Item No. **Report of the Interim Director of Planning, Regeneration & Public Realm**

Address LAND REAR OF 800 UXBRIDGE ROAD HAYES

Development: Replacement of existing car park with new residential building housing a mix of 9 dwellings with car park and associated cycle and bin provision.

LBH Ref Nos: **75956/APP/2022/1527**

2. This drawing is to be used in conjunction with all relevant architect's, service engineer's drawings and specifications.			
Scale	1:200	B-12 Development	
Project	Apr-22	Architectural consultancy	
Drawn By/Checked By	800 Uxbridge Road UB4 0RS	Site Address	Proposed Elevations
			RYUR-AP2-1005

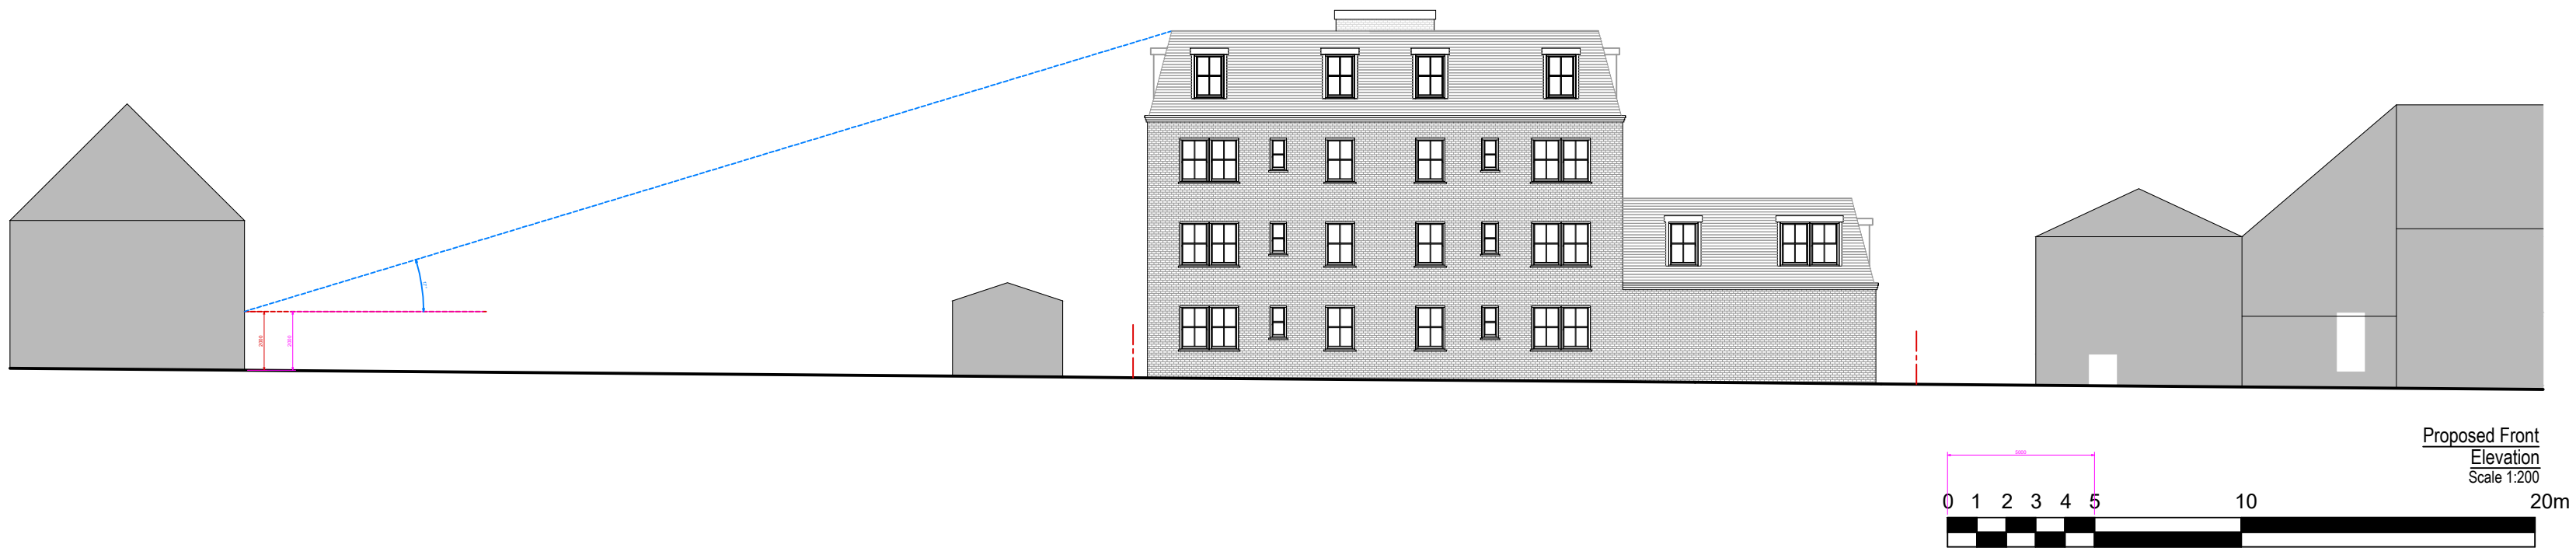
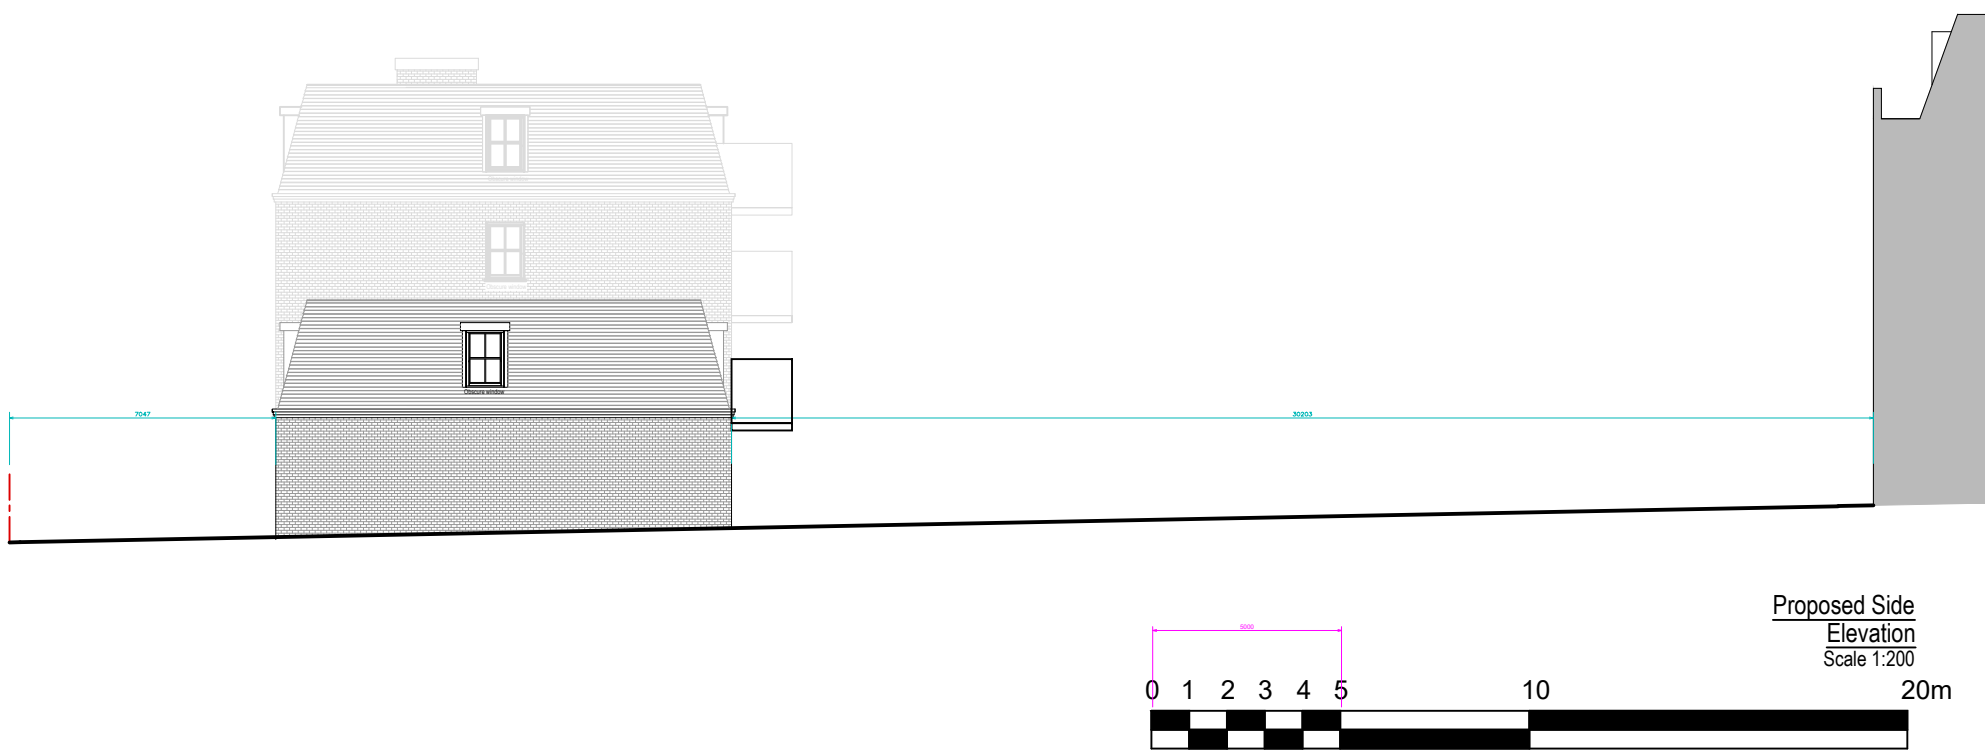
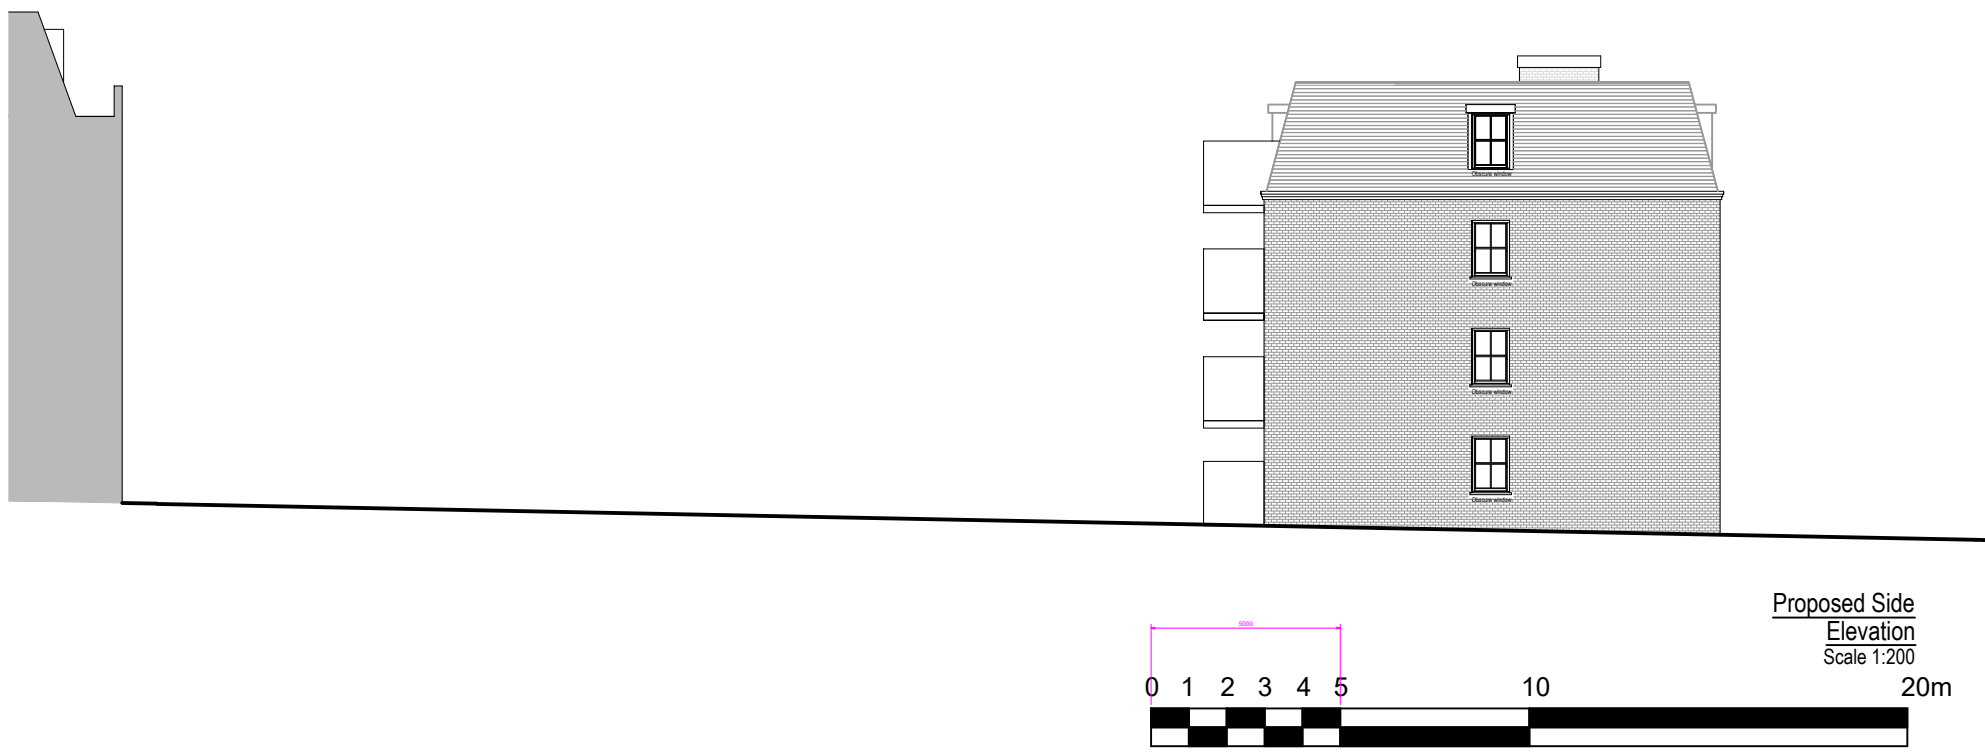
Concerns are also raised with the detailed design of the residential block which appears cluttered and poorly conceived that would harm the appearance of the building and this part of the townscape. The development has an uncomfortable arrangement of balconies which appear visually heavy on the elevation and cut through the eaves line creating an uncomfortable juxtaposition that detracts from the building.

The windows and detailed design of the balcony doors are not complementary and have an uncomfortable relationship with differing glazing patterns resulting in an inconsistent and cluttered facade.

It is also unclear why the bin store doors need to be so wide. Could these not be reduced in size and the more interest added to the facade?

Additionally the building is considered to be poorly designed due to its scale and overly complicated front elevation, comprising 6 dormers, 7 protruding balconies and a plethora of windows with various glazing patterns. Due to its positioning the building would be visible from Uxbridge Road and together its height, backland location and poor design would make it appear as a harmful addition to the area.
